Our Ref: DOC21/291828
Your Ref: SSD 10398

RE: Hanson Tweed Sand Plant Expansion, Cudgen Tweed LGA, (SSD 10398)

Enclosure: Attachment 1: Detailed BCD Comments – Hanson Tweed Sand Plant Expansion at Cudgen (SSD 10398)

FIGURE 10: SEPP (COASTAL MANAGEMENT) 2018 - COASTAL ENVIRONMENT & COASTAL USE AREA

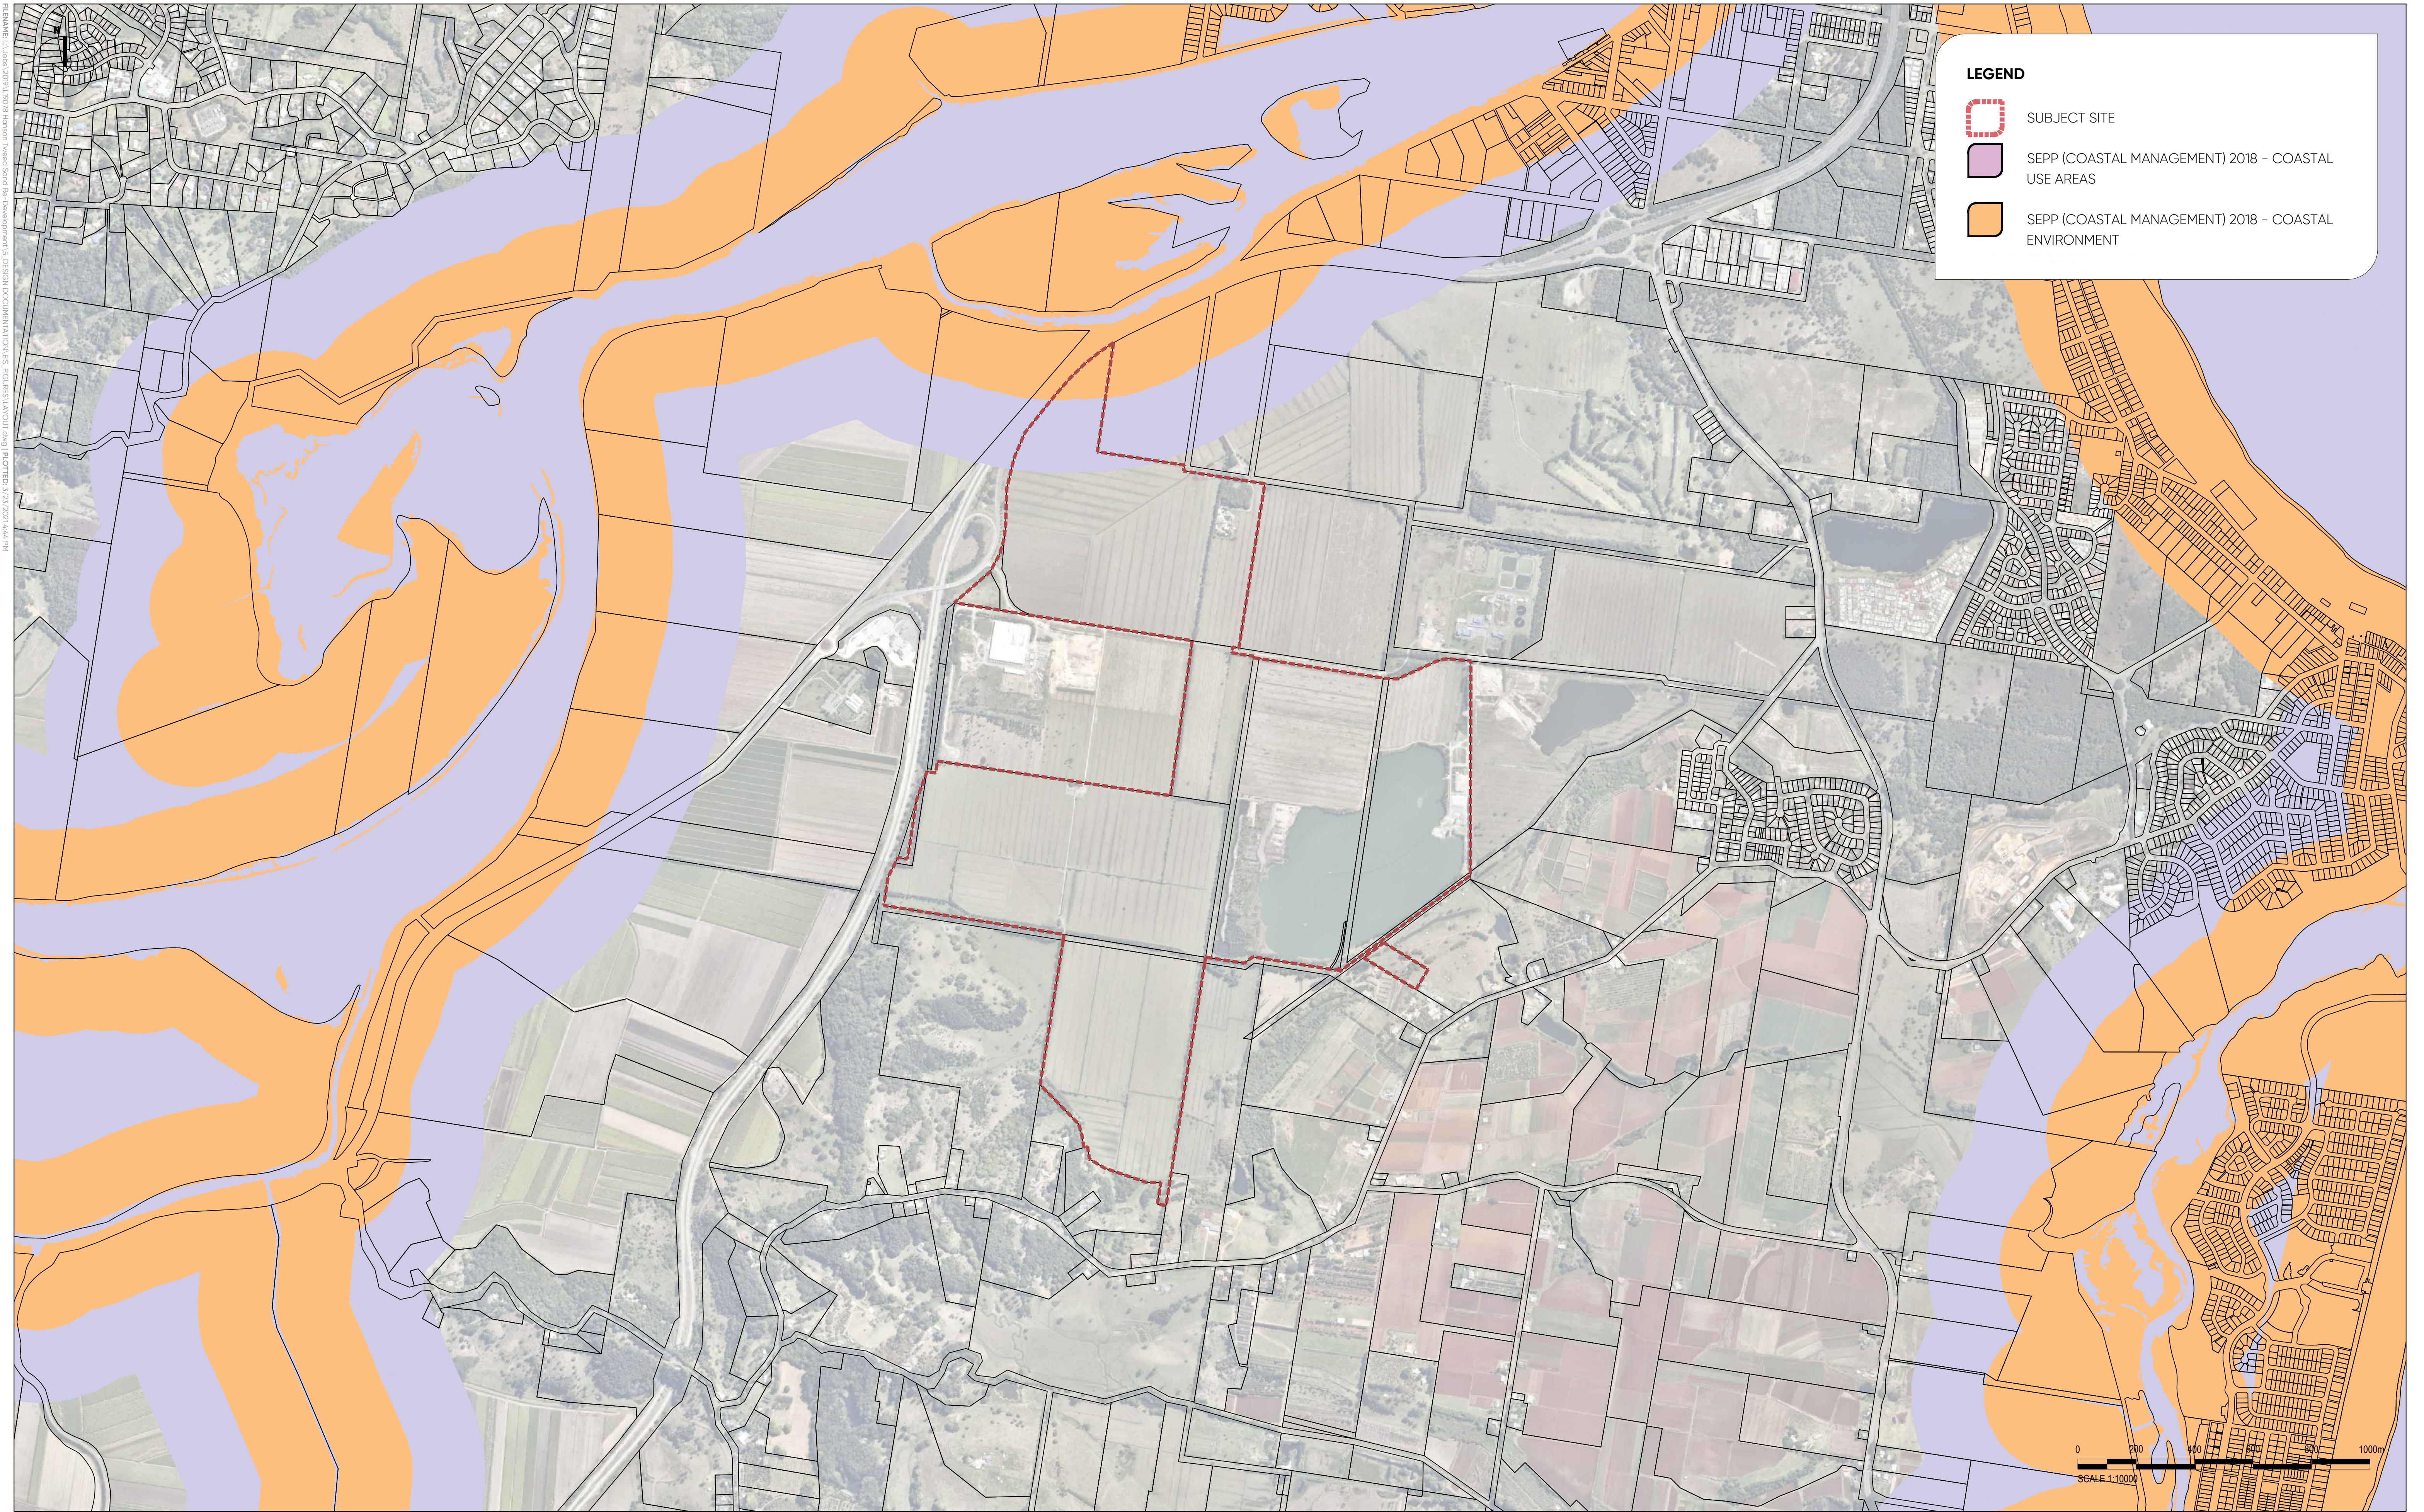
In relation to requirement of the State Environmental Planning Policy (Coastal Management) 2018 (CM SEPP), the EIS documentation in Table 26 (p79) correctly identifies that the “*The north-western most corner of Lot 51 DP1166990 is mapped in the ‘Coastal Environmental Area and ‘Coastal Use Area’ under this policy*”.

Table 26 states “*The proposal has been designed to avoid impacts relating to the items identified in Clause 13 and 14. Development consent can be granted*” and lists the relevant sections and appendices. It should be noted of those sections (6.1.1., 6.1.5.1. and 6.1.10) and appendices, no such section 6.1.5.1 or 6.1.10 exists in the EIS.

Furthermore, when addressing the requirements of Clause 13 and Clause 14 of the CM SEPP, it is not considered adequate to just note that the proposal has been designed to avoid impacts. Rather, each clause and its requirements should be both listed and a full response provided, detailing specifically how the EIS both addresses and satisfies the requirements of each clause.

8. The EIS should be expanded to provide a full response, detailing specifically how the EIS both addresses and satisfies the requirements of clauses 13 and 14 of the State Environmental Planning Policy (Coastal Management) 2018 (Coastal Management SEPP).
9. The following document changes are required:
 - a. Correct the references in Table 26 of the EIS to Sections 6.1.5.1 and 6.1.10 as these do not exist.
 - b. Correct the reference in Table 32 of the EIS to Cumulative Impacts being discussed in Section 5.1.13 which does not exist.
 - c. Address the anomalies in areas identified as riparian restoration and open space/ public use areas in the EIS versus the CRLMP.
